From: Sue Howell <Sue.Howell@arun.gov.uk>
Sent: 27 August 2020 11:30
To: Planning.Responses <Planning.Responses@arun.gov.uk>
Cc: Simon Davis <Simon.Davis@arun.gov.uk>
Subject: RE: Planning Consultation on: Y/39/20/RES

Application ref: Y/39/20/RES

Description: Approval of reserved matters following outline consent Y/49/17/OUT & Section 73 permission Y/13/19/PL for 45 No. dwellings & associated works. This application may affect the setting of a Listed Building.

Location: Land at Street Building North End Road Yapton BN18 0DT

Refer to Fabrik drawing D2832_FAB_1_GL_DR_L_0301 for the Landscape Legend

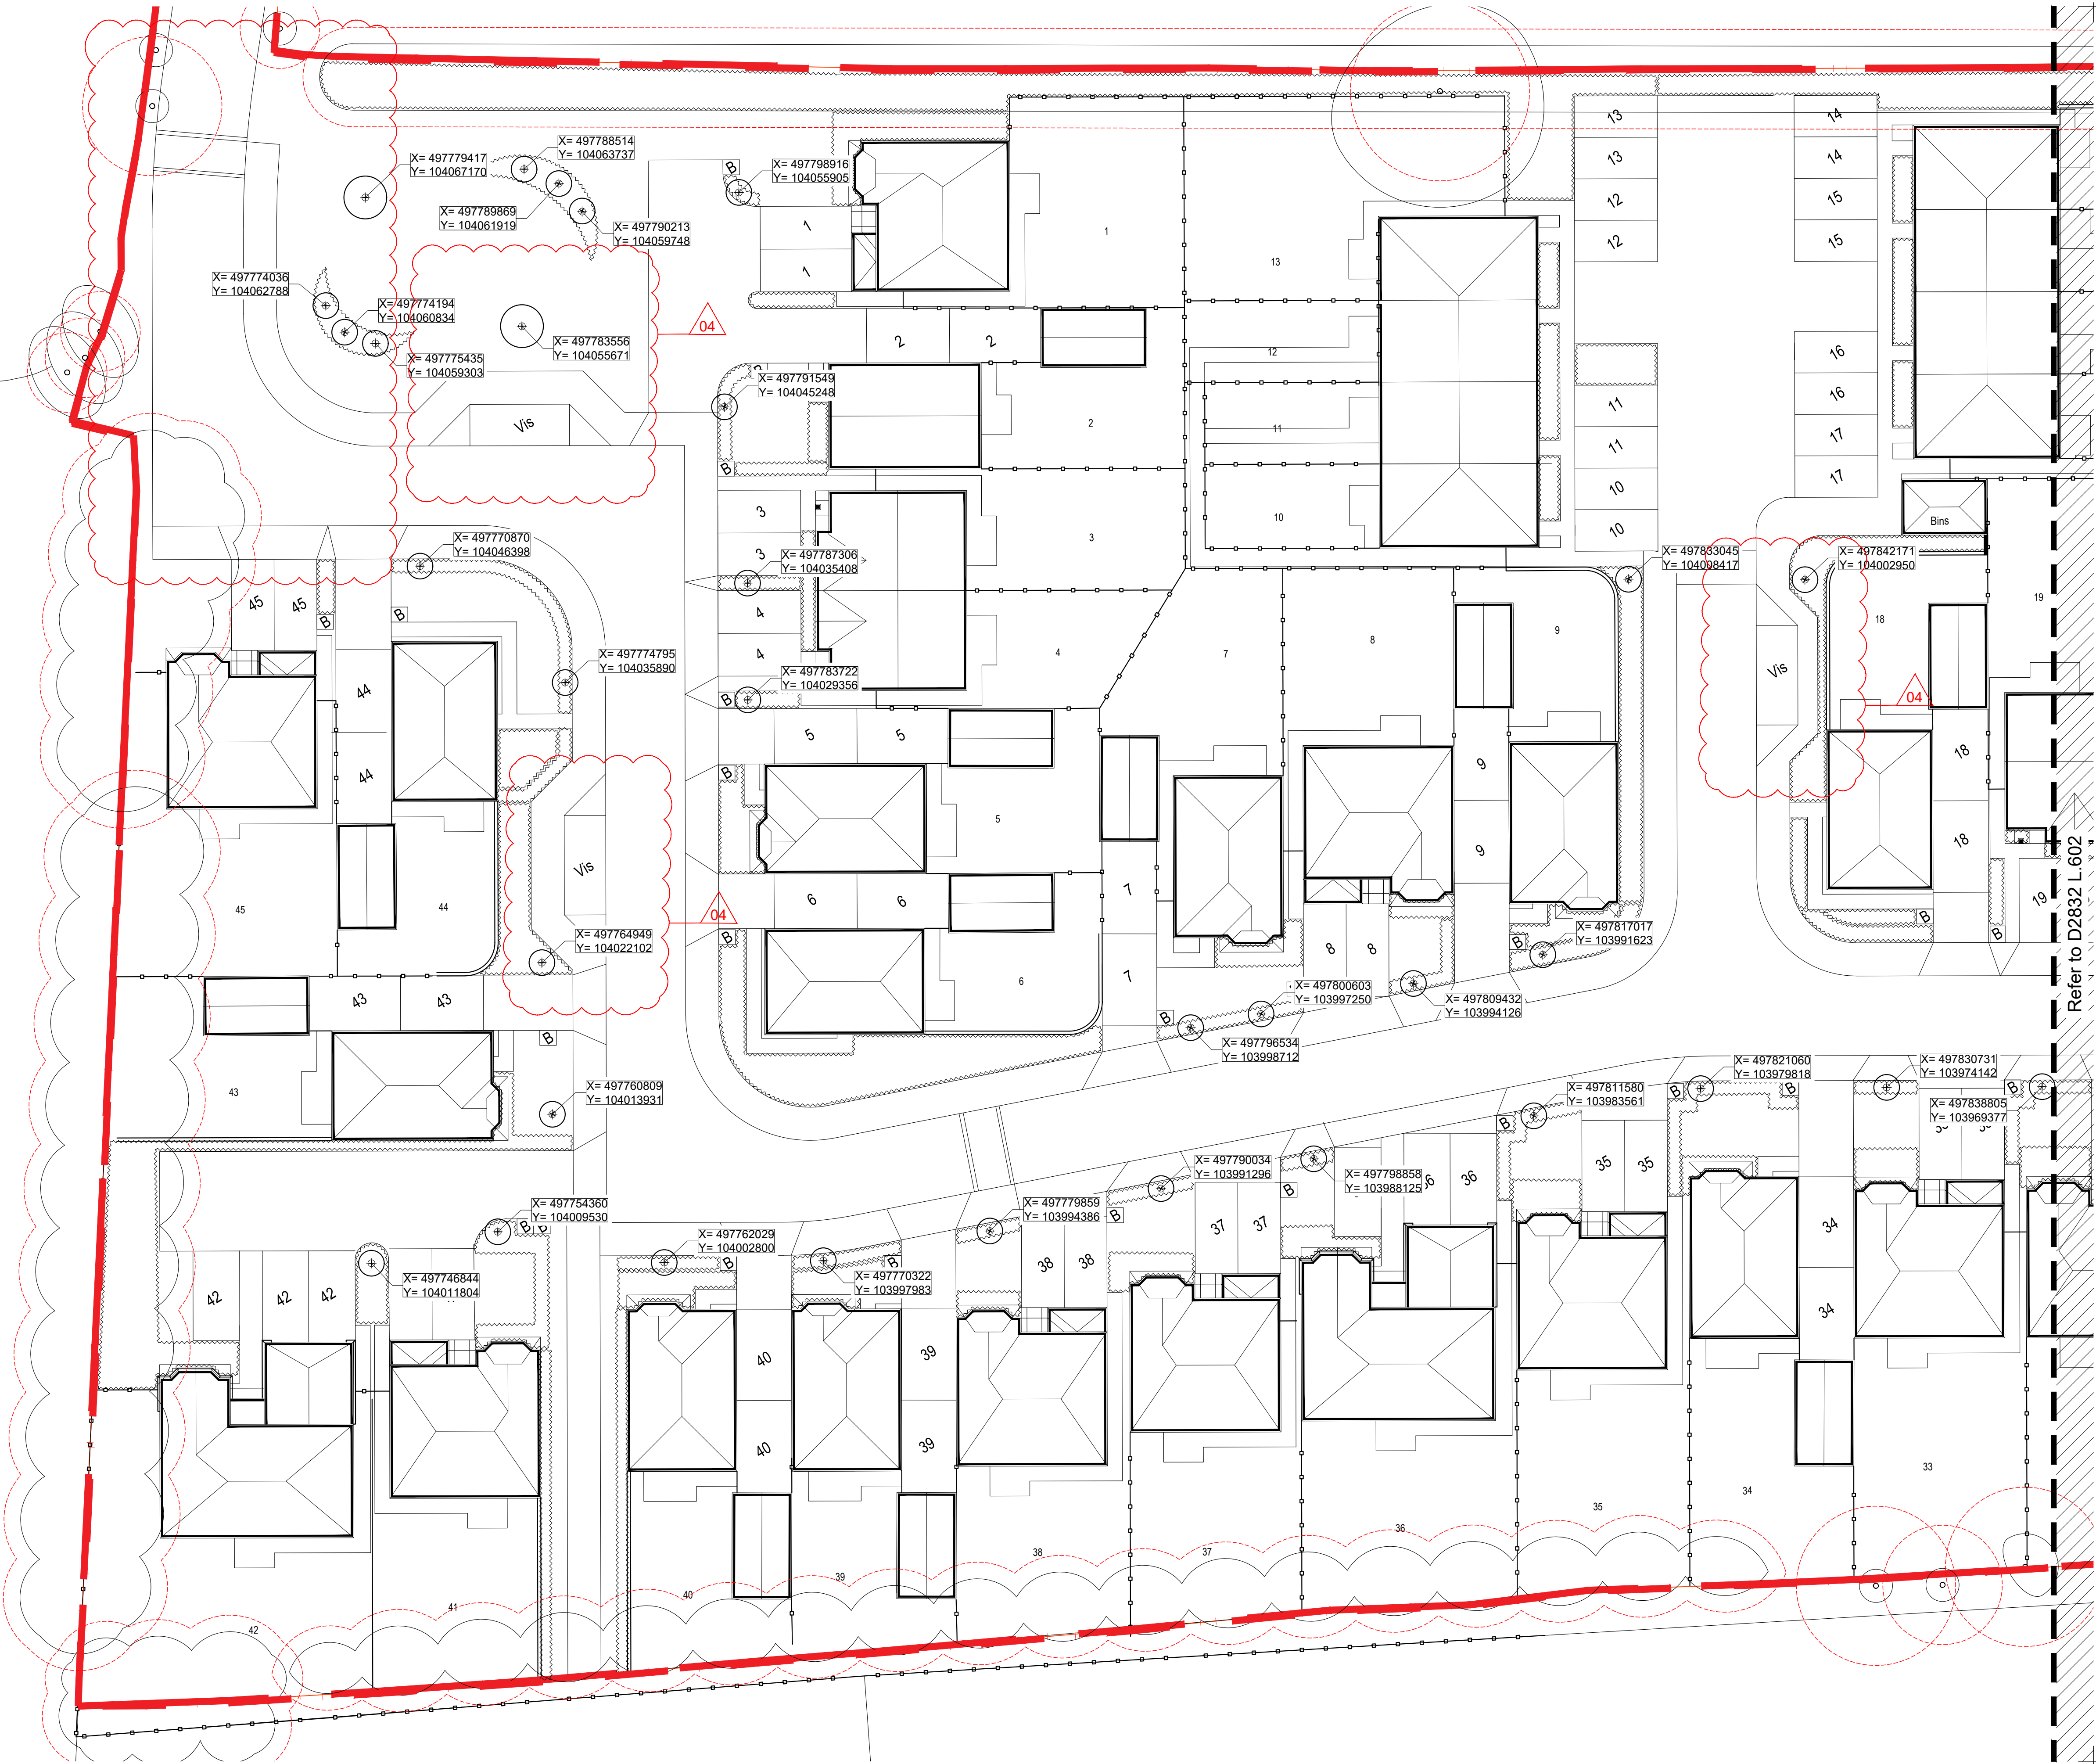
One minor area for revision would be the rectangular block of scrub mix area to the north of Plot 13. (sheet 1 of 2) This area does not appear in this revision to connect to the perimeter scrub planting and would also be unsuitable in species choice in this location. It would be beneficial to see this as either a grassed area or planted with the same ornamental mix as contained adjacent to Plot 1 frontage area.
